**SUNDERLAND CITY COUNCIL'S RESPONSE TO THE EXAMINING
AUTHORITY ISSUES AND QUESTIONS RELATING TO THE DRAFT
DEVELOPMENT CONSENT ORDER AGENDA FOR ISH: 13 AUGUST 2019
TABLE 1 ANNEX E**

Q No.	Part of DCO	Drafting example (where relevant)	Question
21	Art 11(2)	<i>"From such day as the undertaker may determine no person is to drive any motor vehicle at a speed exceeding the limit of 40 miles per hour on the roads described in columns (1) and (2) of Part 4 of Schedule 3 (classification of roads etc)".</i>	Sunderland City Council ('SCC') is supportive of the 40mph speed limit and has no issues.
24	Art 12(6)	<i>"If a street authority which receives an application for consent under paragraph (4) fails to notify the undertaker of its decision before the end of the period of 28 days beginning with the date on which the application was made, it is deemed to have granted consent"</i>	SCC is aware of the 28 days' time period in which to make a response to a request for consent or it will be deemed consent. SCC considers that it should be able to respond in that time scale and that this time scale is in line with the nearby Testo's DCO.

Drawing Title **PROPOSED CHANGES TO NON-MOTORISED USER ROUTES**

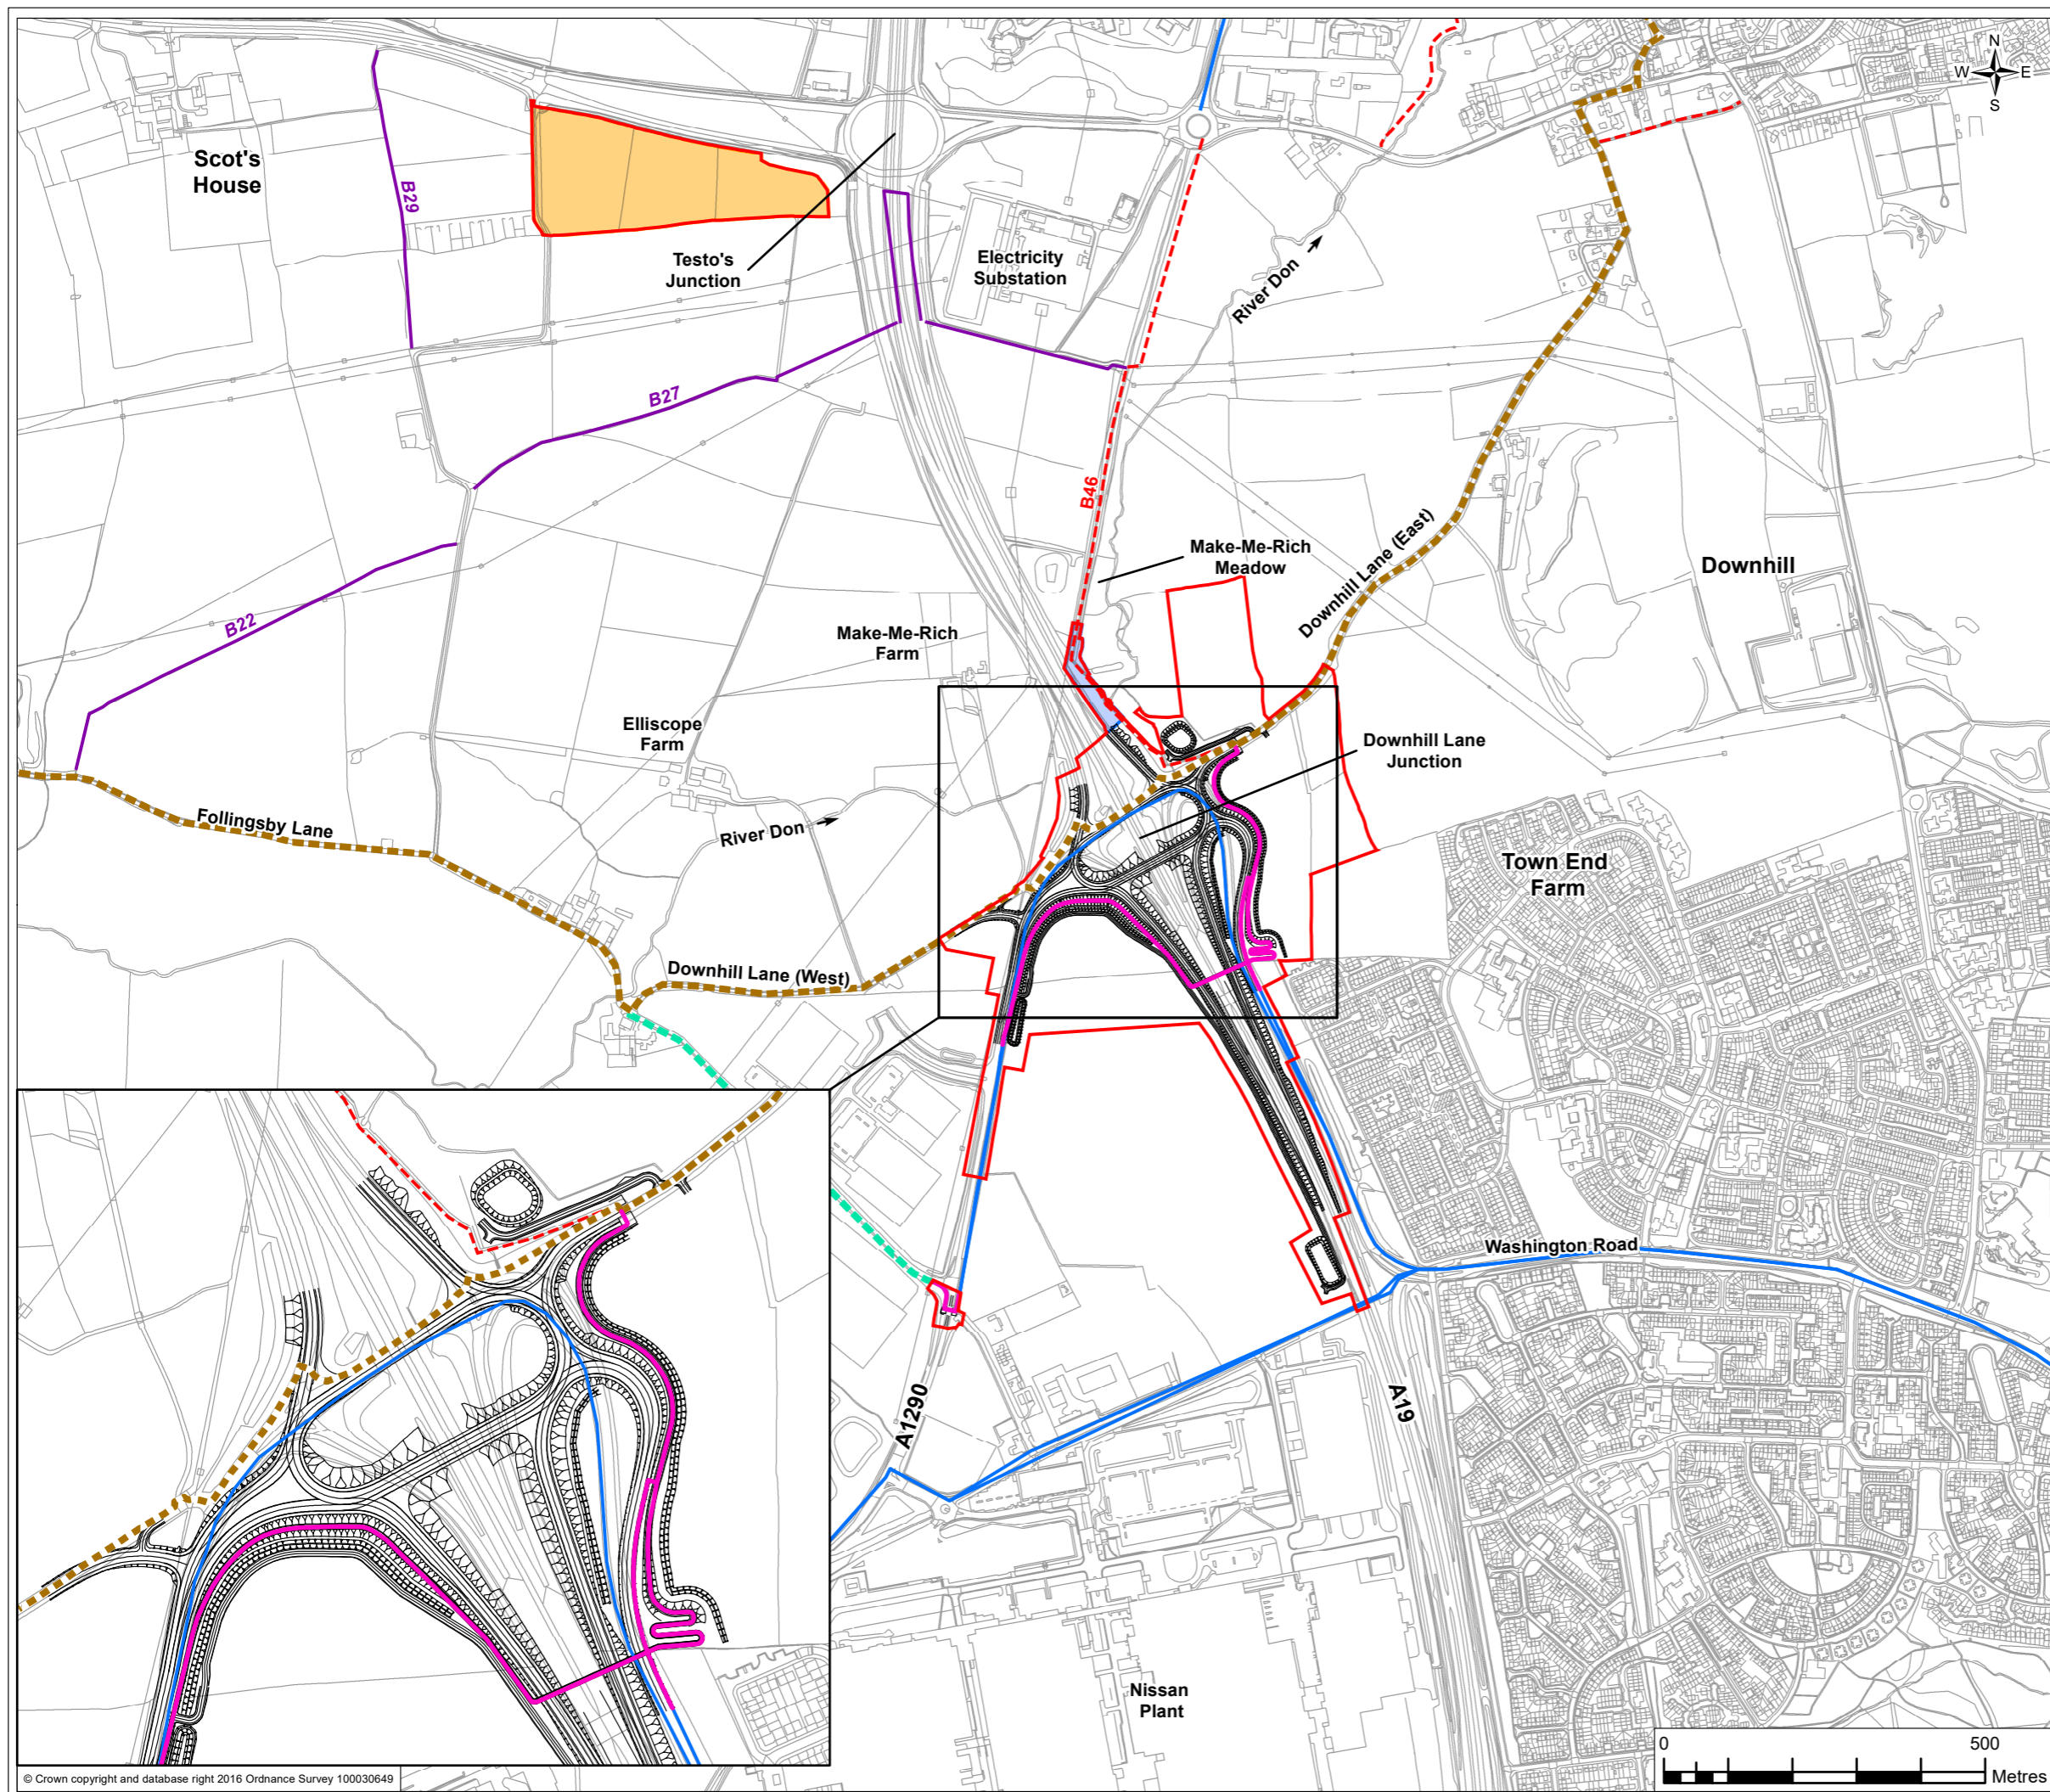
41	Schedule 2, R3	<i>"(1) The authorised development must be designed in detail and carried out in accordance with the preliminary scheme design shown on engineering drawings and sections unless</i>	SCC note that the current scheme design is at a preliminary design stage. It is noted that the applicant is proposing an alternative alignment for the non-
